Our reference: DOC15/143450

**RE: 09_0145 MOD 1 - ELF Farm Supplies - Proposed Modifications to Mulgrave Substrate Plant
EPA Submission to Public Exhibition**

I refer to the public exhibition of Elf Farm Supplies Proposed Modifications to Mulgrave Substrate Plant 09_0145 Mod 1. Elf Farm Supplies provided Perram and Partners *Environmental Assessment Report 136R2* dated February 2015 ("the Environmental Assessment") in support of the application.

Figure 6 Early Construction for Ammonia Scrubbers and Biofilter

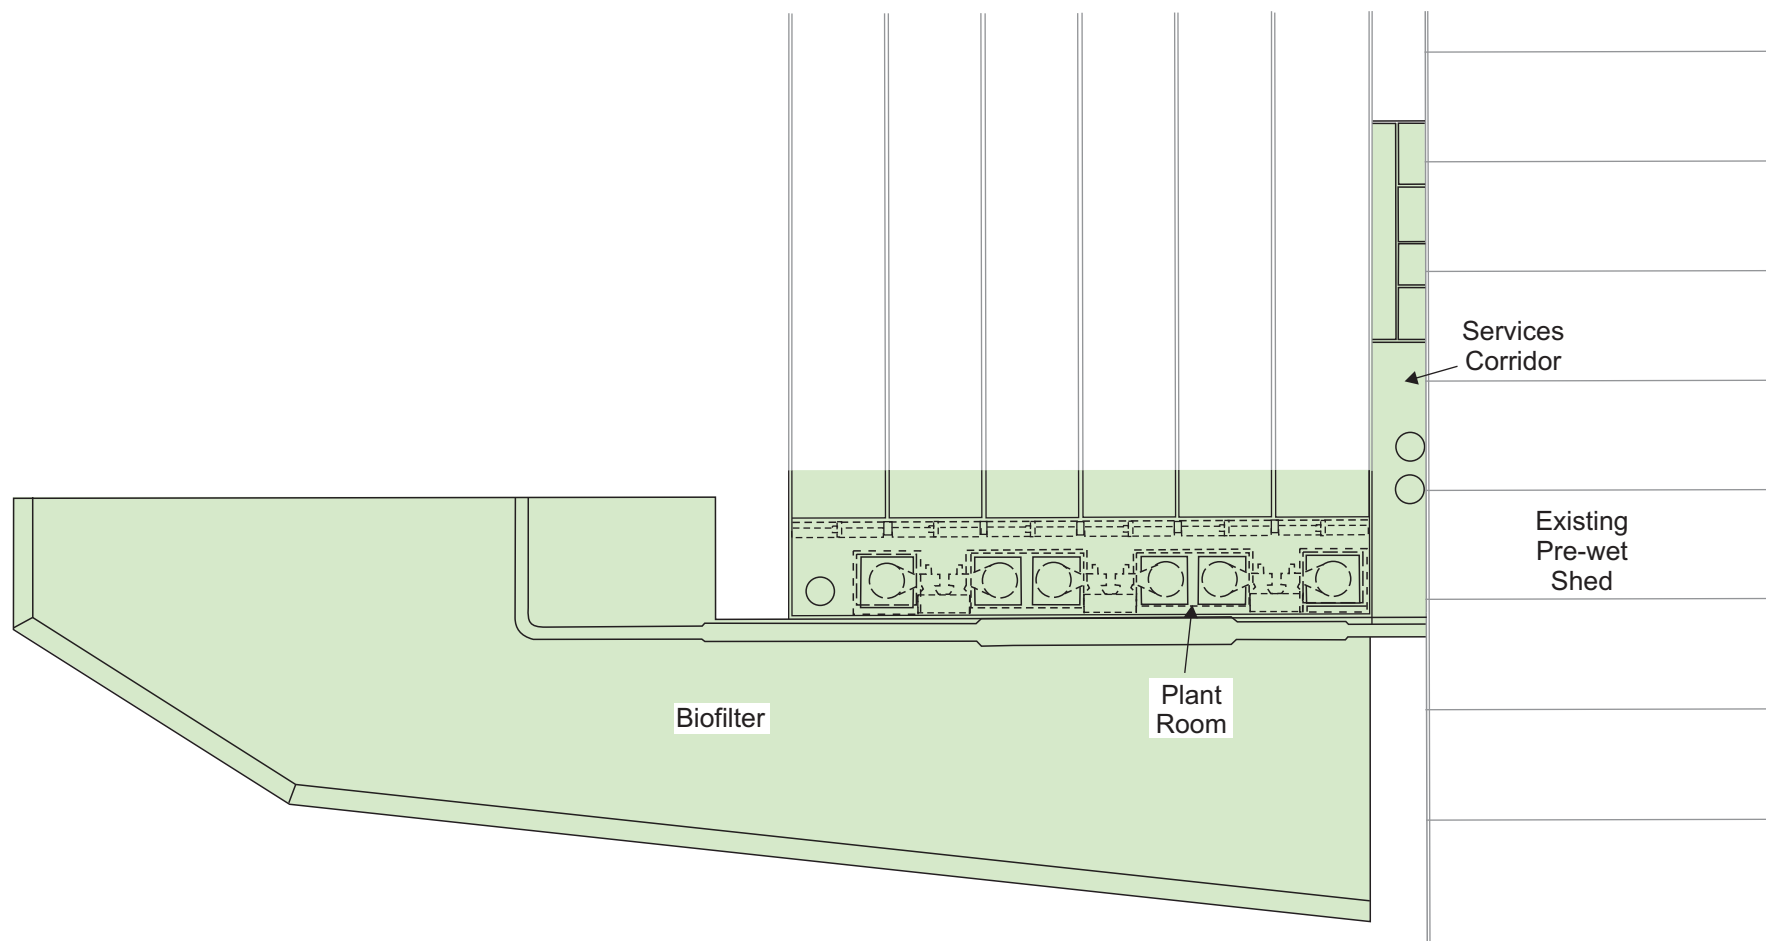
- 1. No increase in throughput until odour control works are validated and approved by EPA
 - a. Figure 6 of main assessment document has half the second 2/3 building being built at the same time as these works. Further, three extra tunnels will be added to the existing phase 2/3 building to increase composting time. The existing approval should be upheld which requires that no further increase to the volume of substrate production shall be approved until EPA has provided written advice that odour mitigation measures effectively control emissions to ensure compliance with the requirements of the POEO Act;
 - b. Schedule 2 production rates conditions amended to include that the Director General consider EPA advice regarding compliance with POEO Act prior to allowing further increase

FIGURE 3 Proposed Pre-Wet Structure and Biofilter

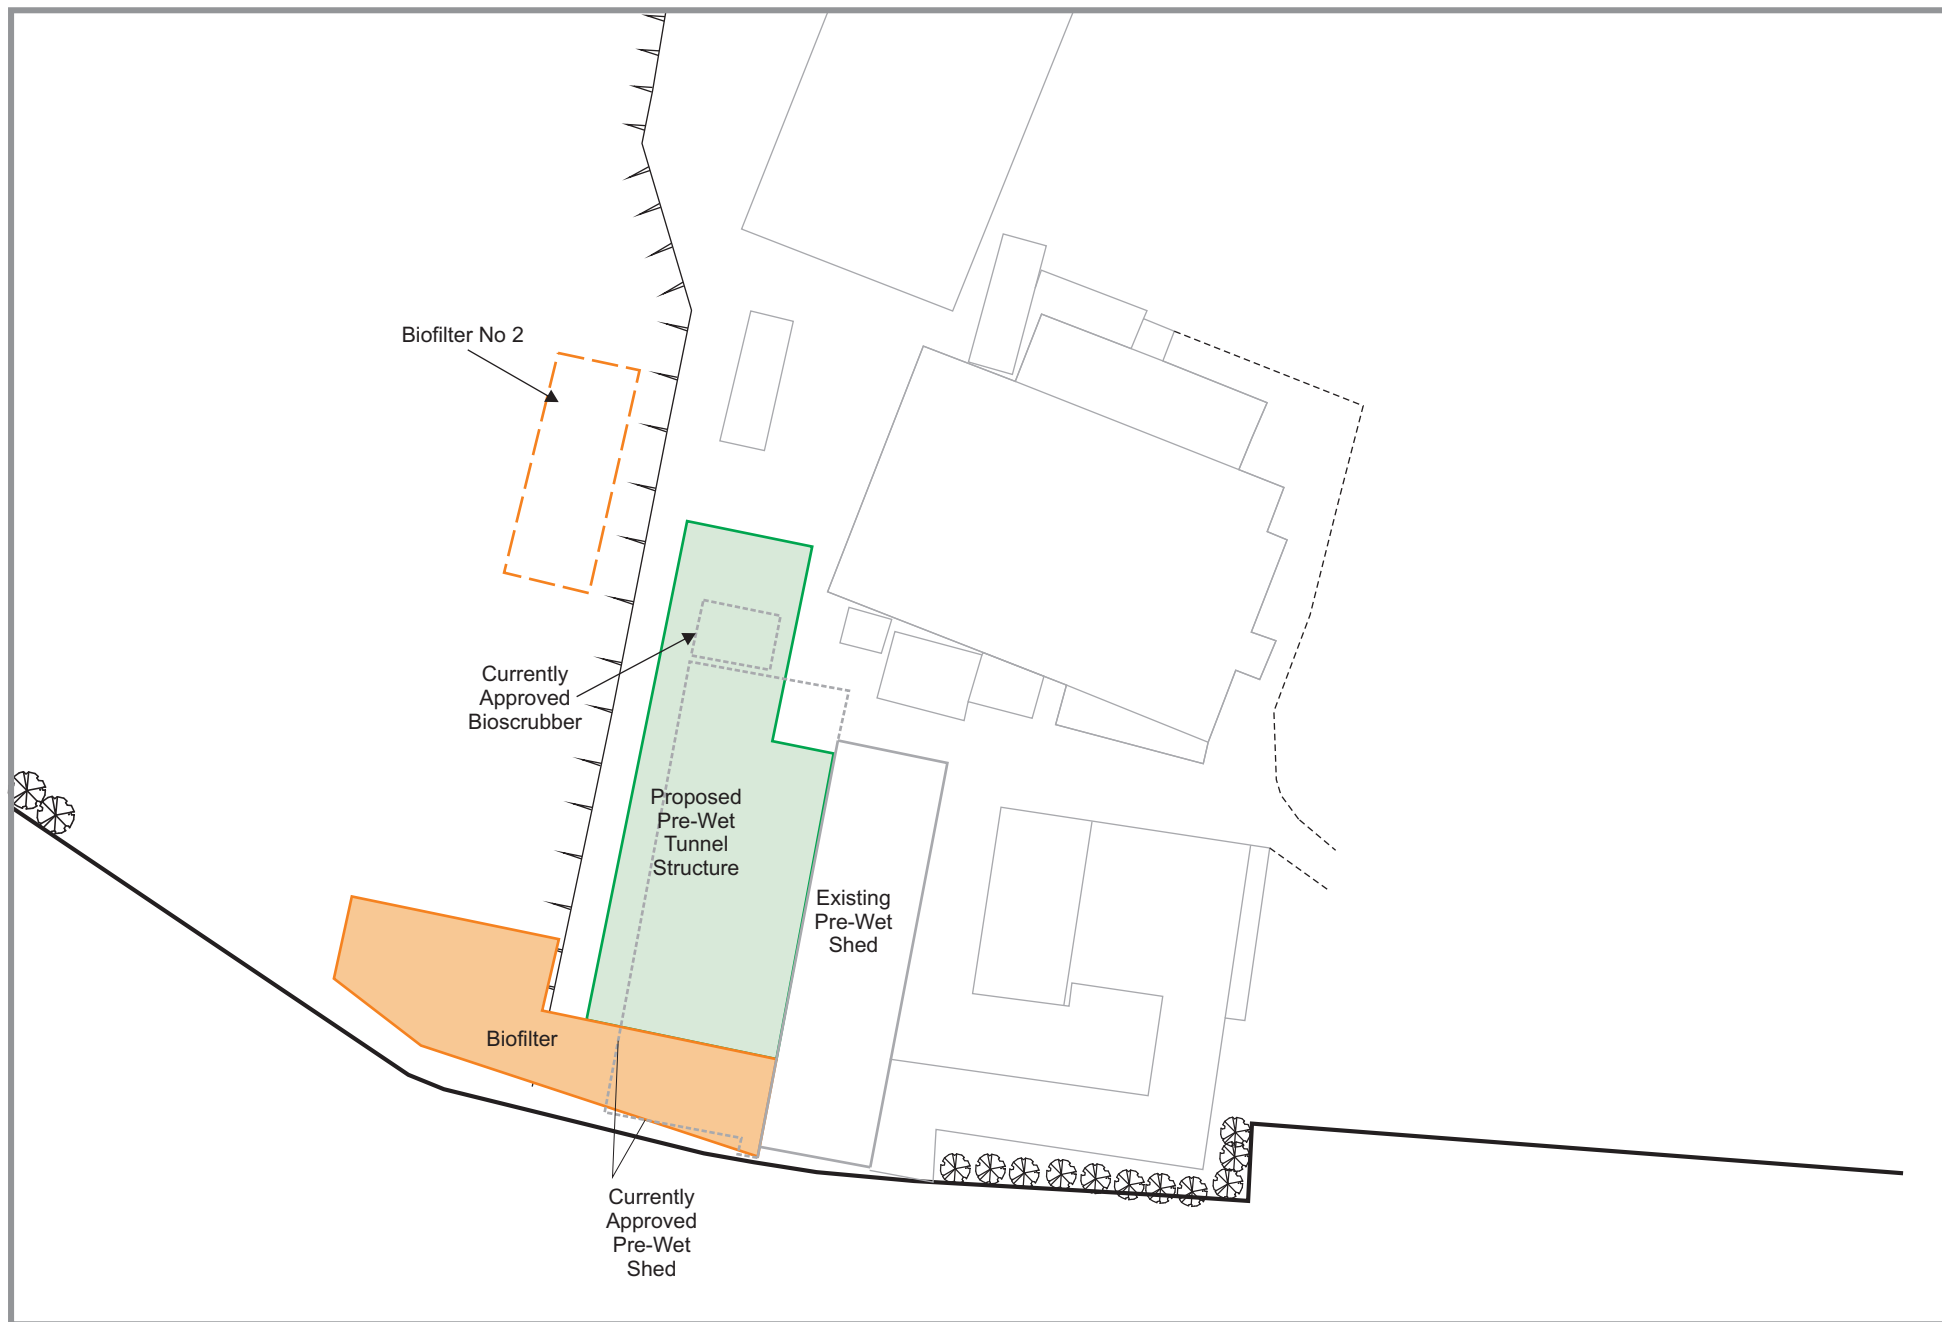
1. A clear and unambiguous discussion of the works and modifications to existing consent conditions for which approval is being sought;
2. Information about the performance specifications of the second proposed biofilter to the north of the pre wet building;
